**Maker Heights, Rame
Carpark Re-configuration
Design Report**

J22/052
January 2024

3.0 Feedback from Historic England

01 Site Plan - Proposed
Scale 1:200

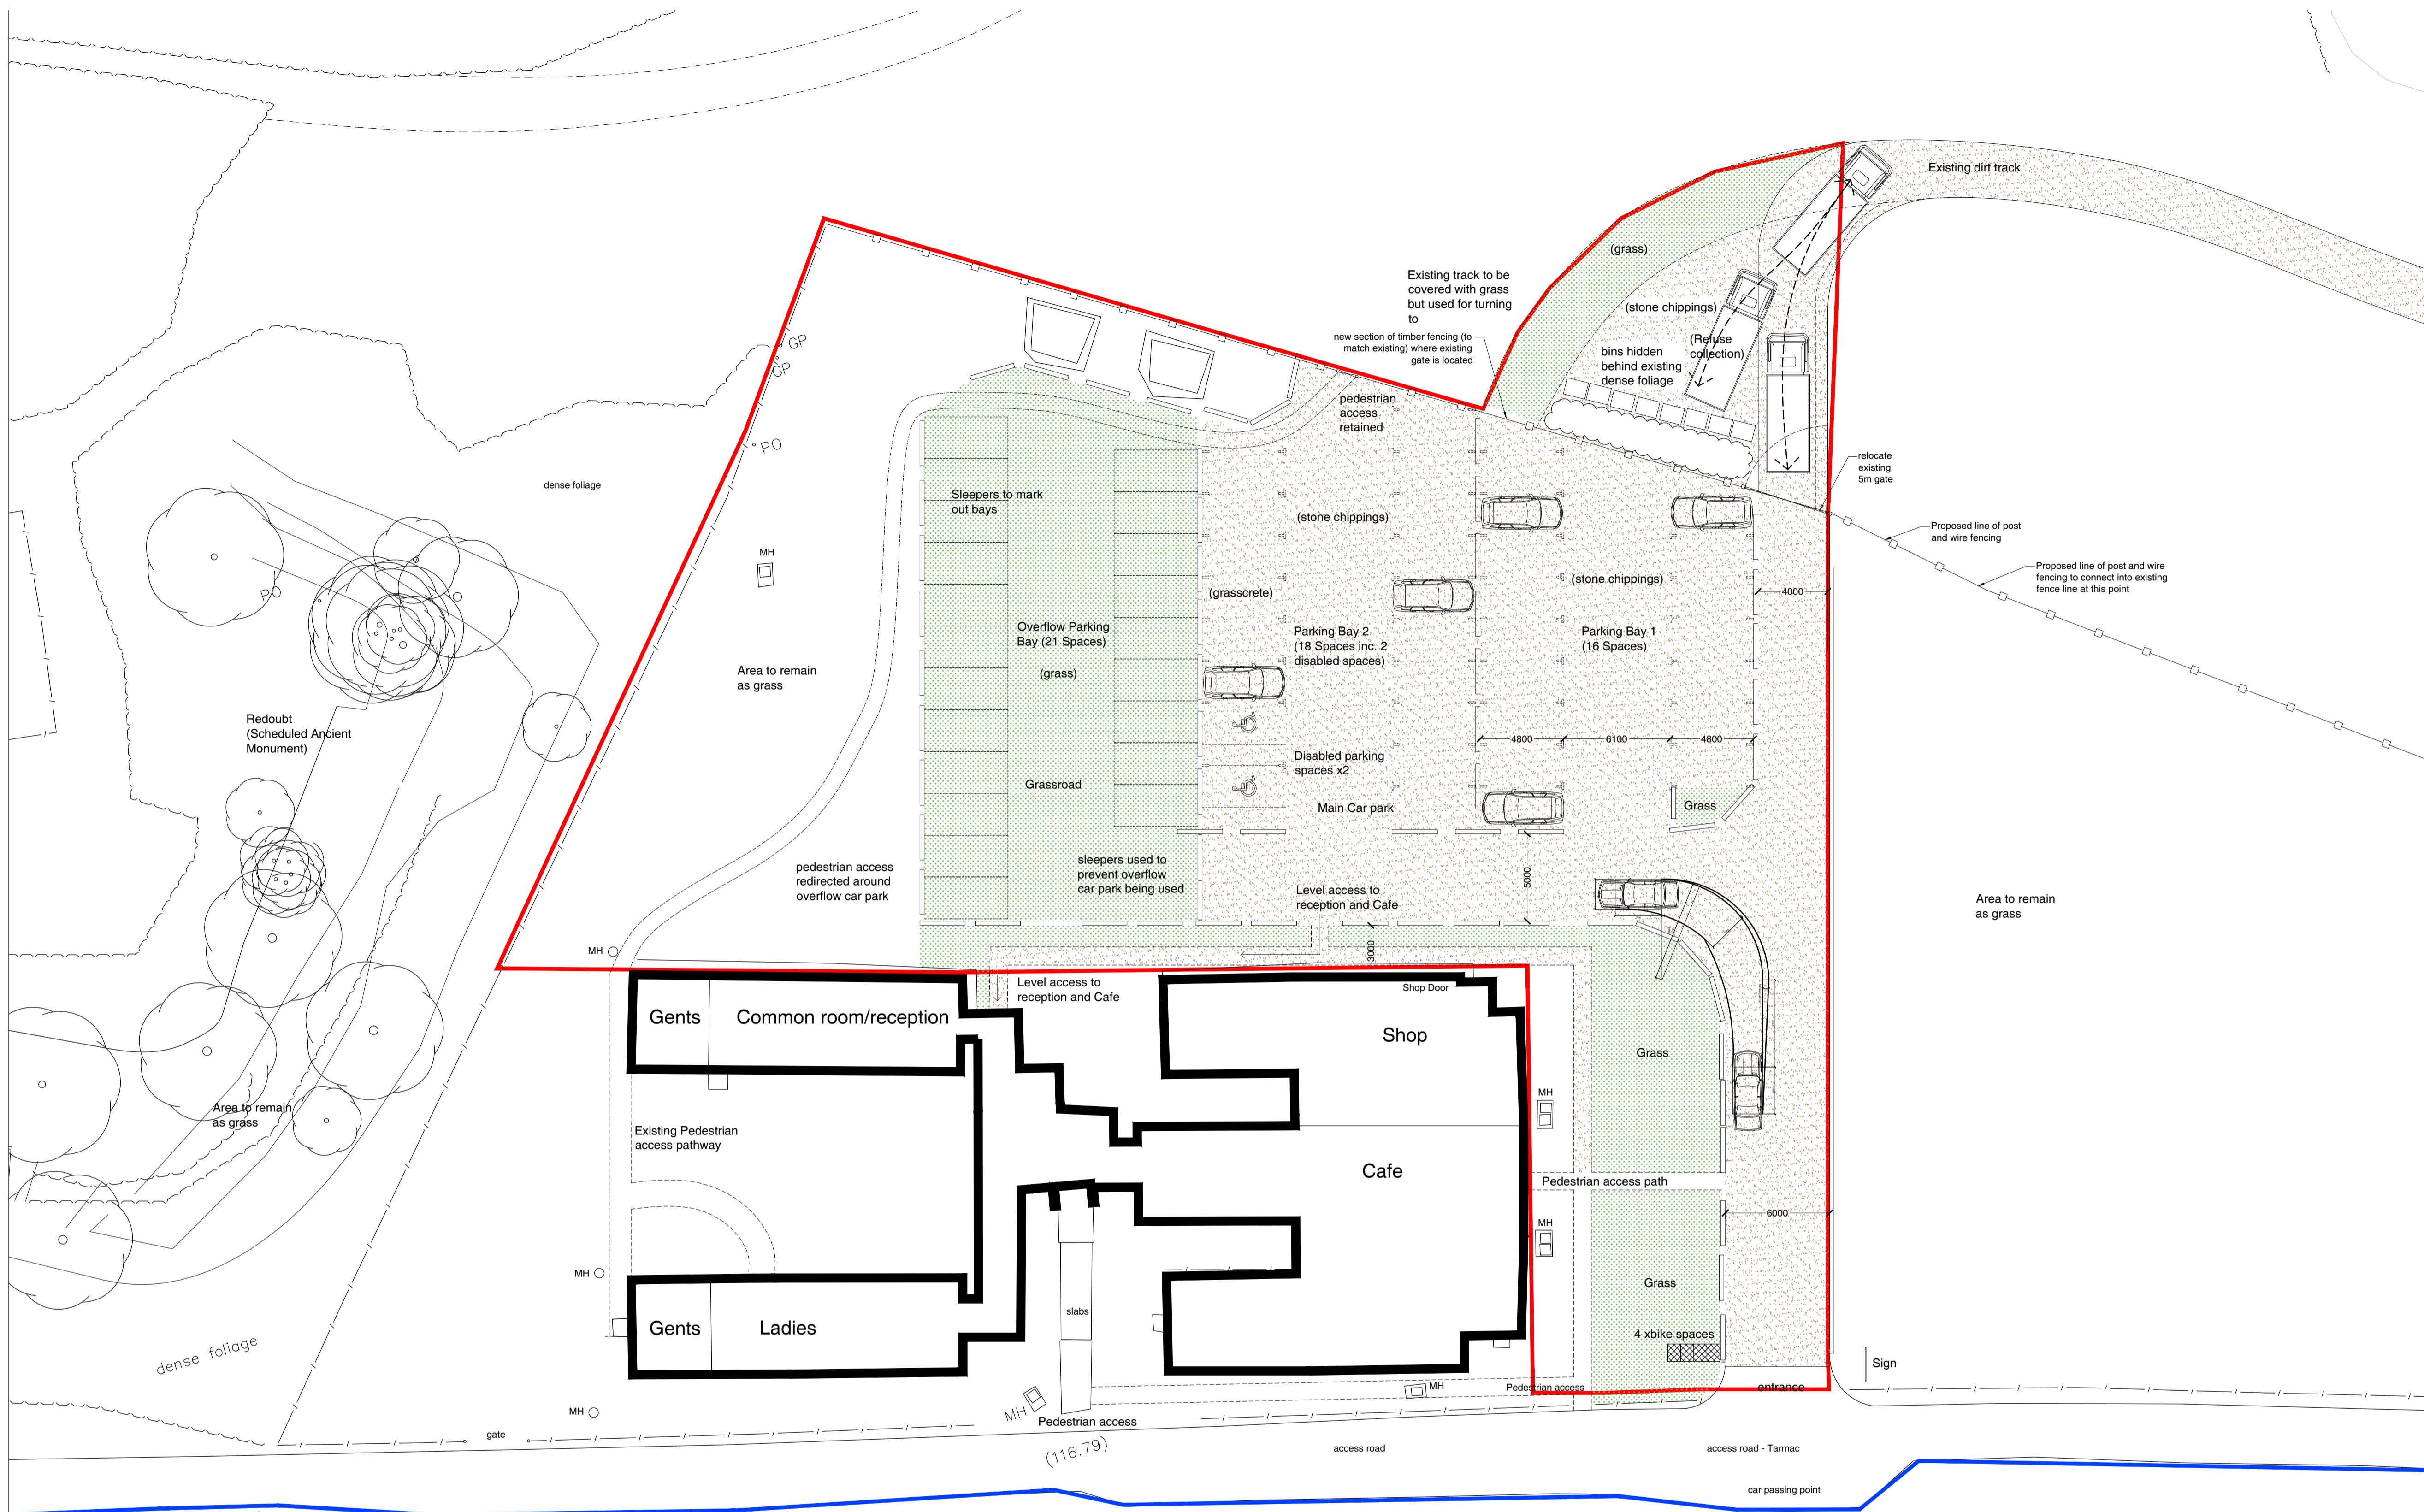
- 1. Making sure that surfacing materials reflect the natural colours of the site*
- 2. The delineation of parking areas are as per the existing painted logs*
- 3. Parking for the disabled is relocated into the existing gravel surface area*
- 4. The overflow parking area is retained as a green/grassed space and is only used as an occasion*
- 5. Fencing is retained as is, or made even more discreet*
- 6. 'Waiting area' for camper vans etc. is retained as an informal location, rather than a delineated space*
- 7. Bins do not need to be screened, but they could be located behind the fence opposite the 'waiting area'*

1. Surfacing materials - the proposed scheme is for grassroad to the overflow carpark, ensuring its appearance remains natural for the majority of the year as this carpark will only be in use during large events (preventing parking on the verges etc around the site). Grasscrete was considered but there is better grass coverage (90%) with Grassroad and it is suitable for overflow car parks and is a lightweight, low-build structure. A brochure has been included as part of this application for additional information.

The main carpark material is a dark brown/red gravel (see photographs 10 - 14) to reduce the visual impact and make it look like earth rather than a white or grey stone that would be a scar on the landscape. This would be an improvement on what is currently used for the carpark (light grey).

2. The proposal is to retain the use of sleepers to denote the parking spaces. It should be noted the dashed outline of the spaces on the plan is to indicate where the spaces are proposed, but no markings on the ground will be used.

3. The disabled parking has been shown in the second bay of the main carpark to ensure the entire overflow carpark is only to be in use when there is the need for it during events.

4. As noted above in surface materials the overflow carpark is to be grassroad, it was felt this rather than grass would be best as it will provide more protection to the earth whilst providing a high percentage of grass cover.

5. The fencing is to remain as it is. The proposal does put forward a slight move in the fence line, this allows 2 additional carparking spaces which are needed.

6. Waiting area has been removed and camper vans etc are to park in the carpark whilst checking in.

7. Bins have been moved behind the existing foliage and collection adjusted accordingly. No additional screens are proposed.
